Re: Liverpool City Council's Review of Response to Submissions for SSD-10446, 275 Adams Road, Luddenham

Council was invited to provide comments on the proponent's response to submissions for a proposed resource recovery facility.

DRAWING TITLE
LANDSCAPE GENERAL
ARRANGEMENTS PLAN
SHEET 3

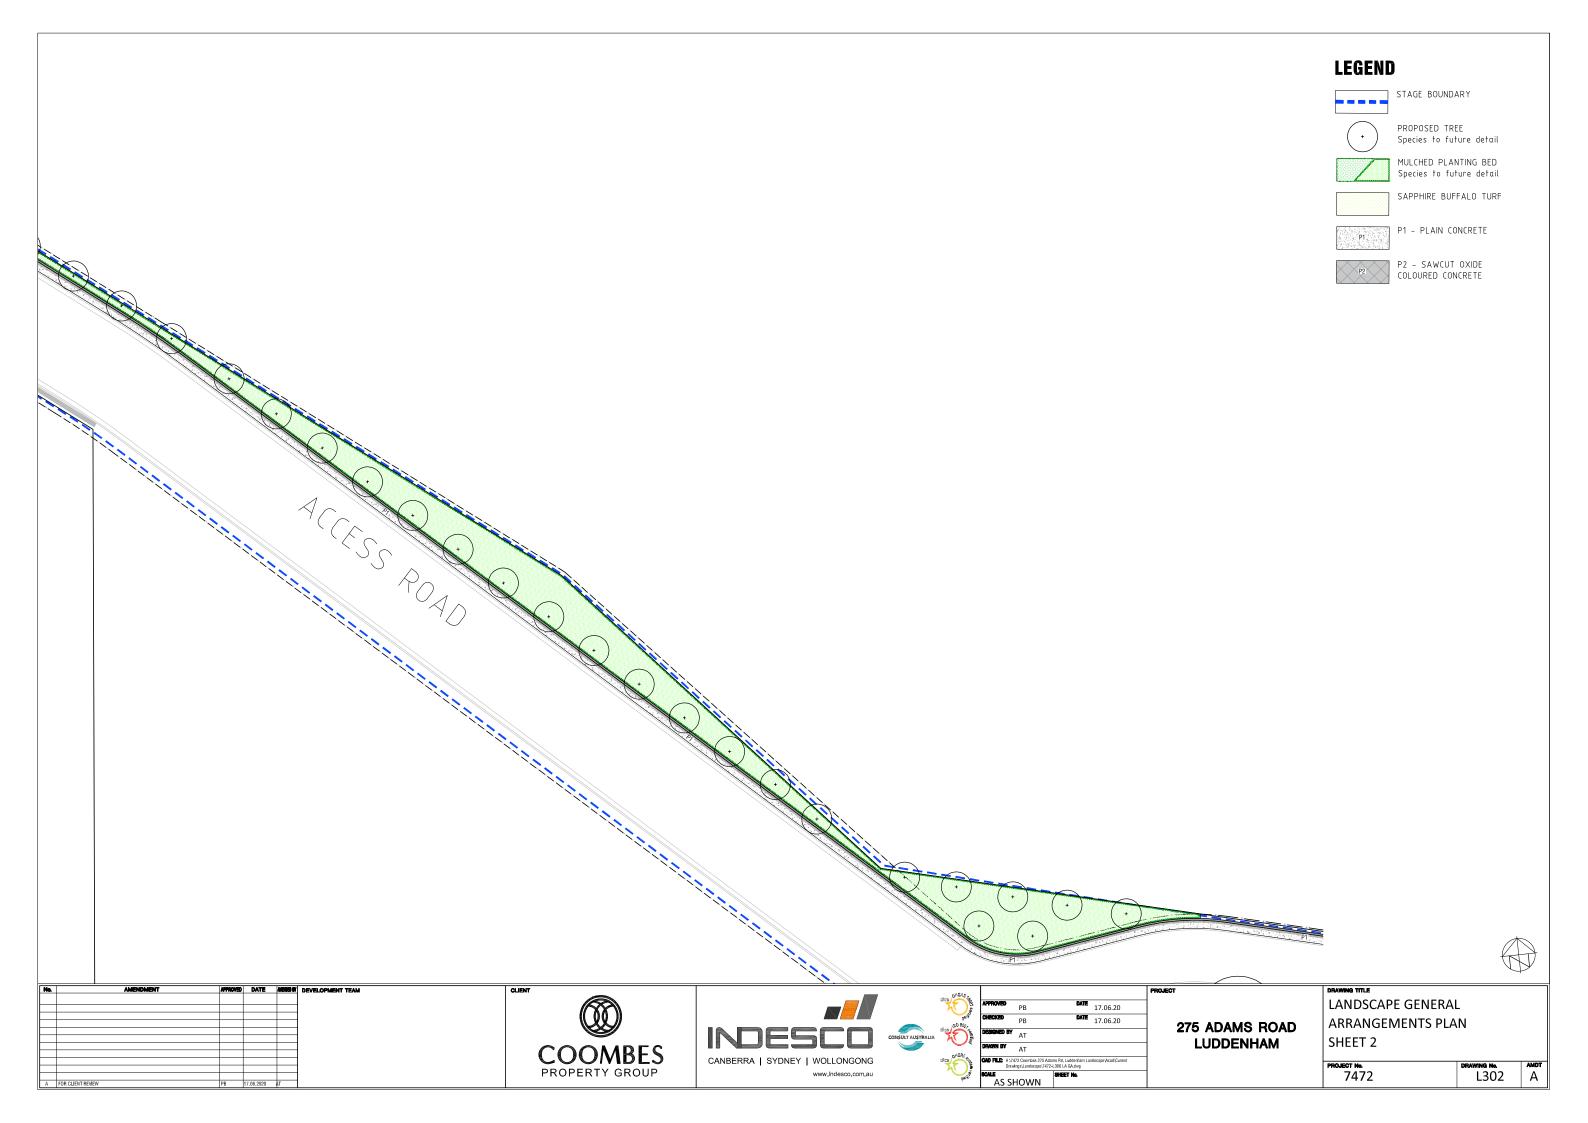
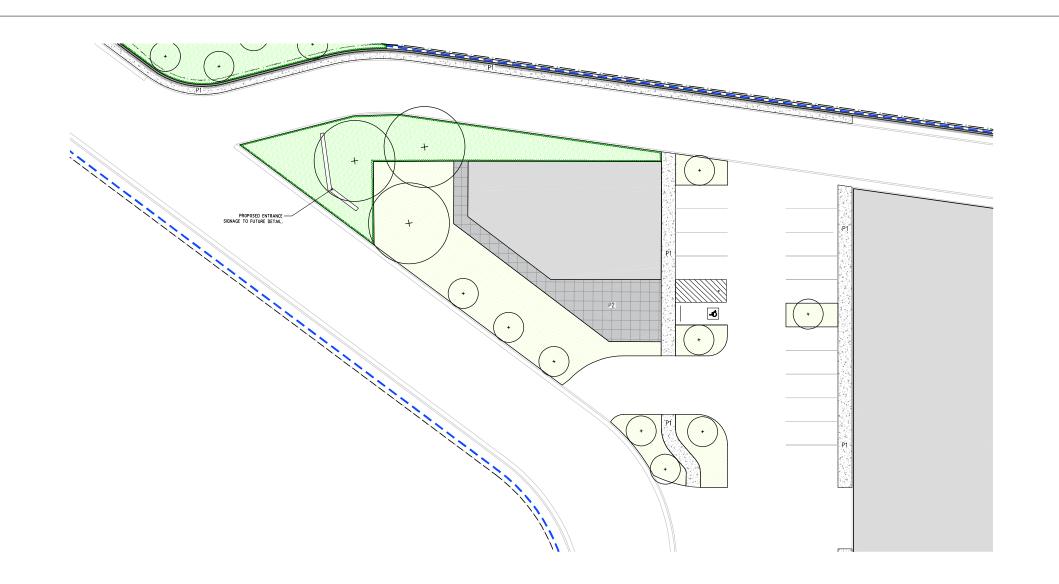
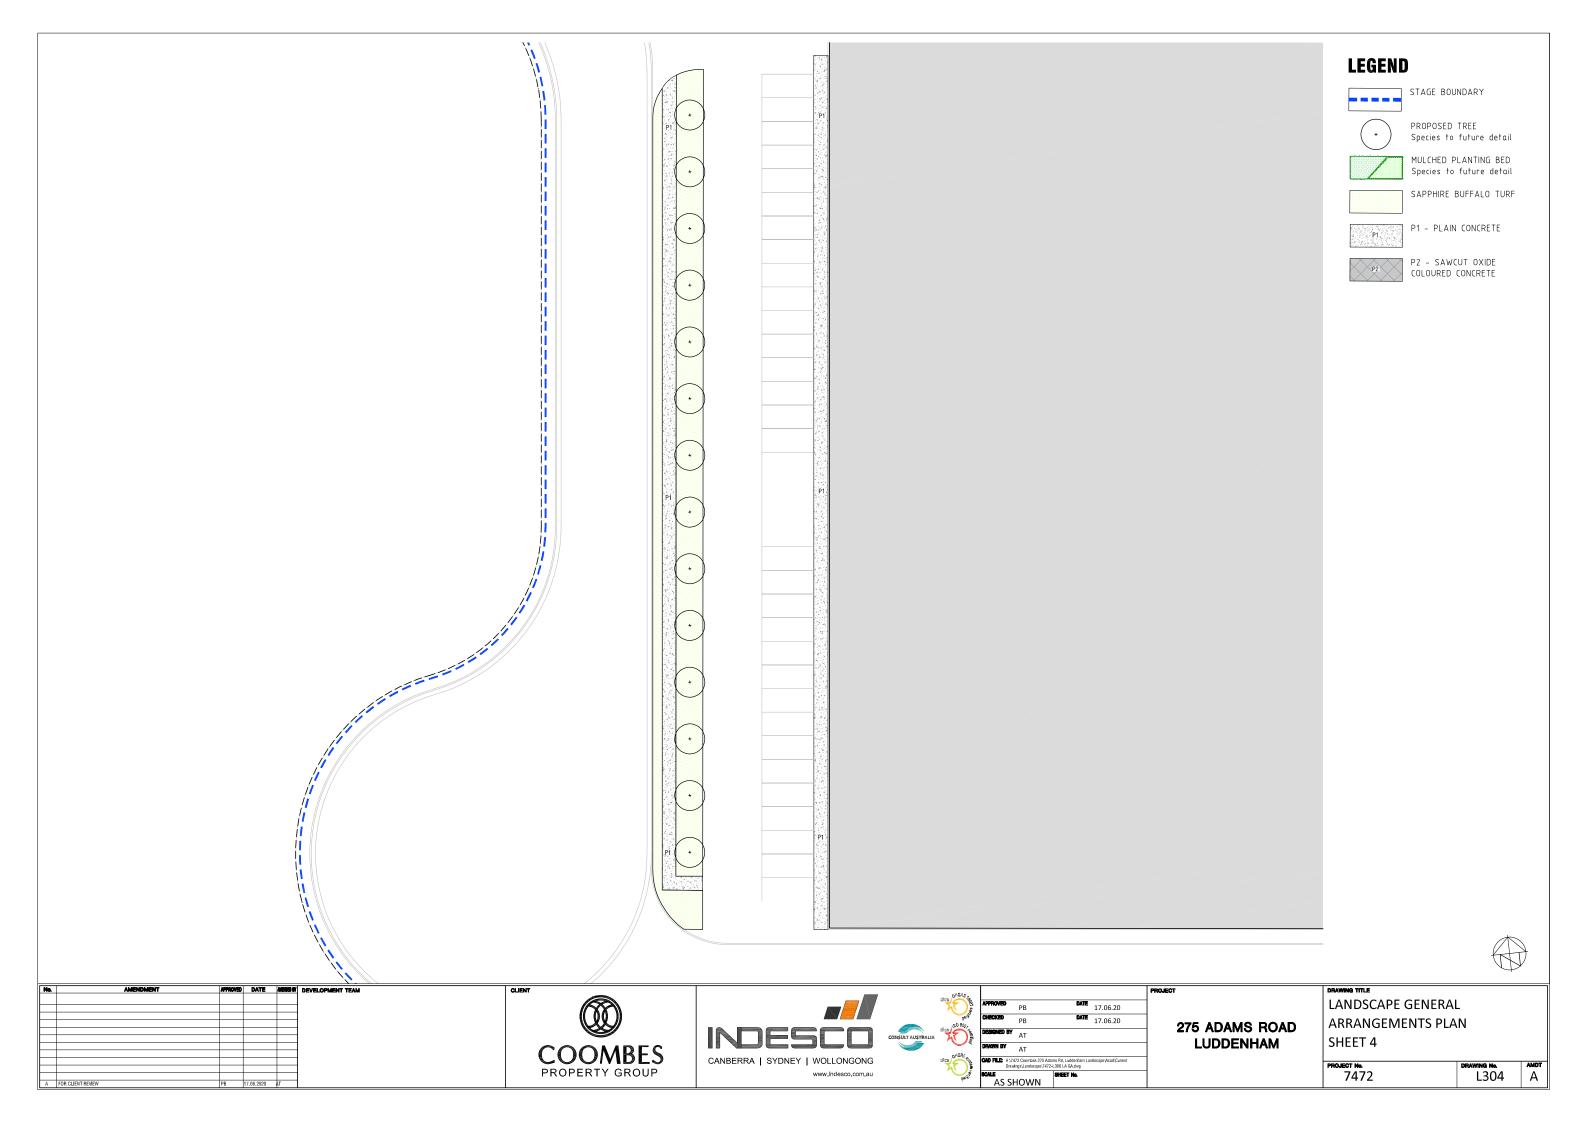
Council staff recommend that DPIE works with the proponent to identify an alternative species to replace areas to be planted with *Acacia longifolia*. The replacement should offer greater longevity and be suited to the conditions/environment in which these trees would be planted. Appendix 2 of Part 1 of Liverpool's DCP has a list of preferred species.
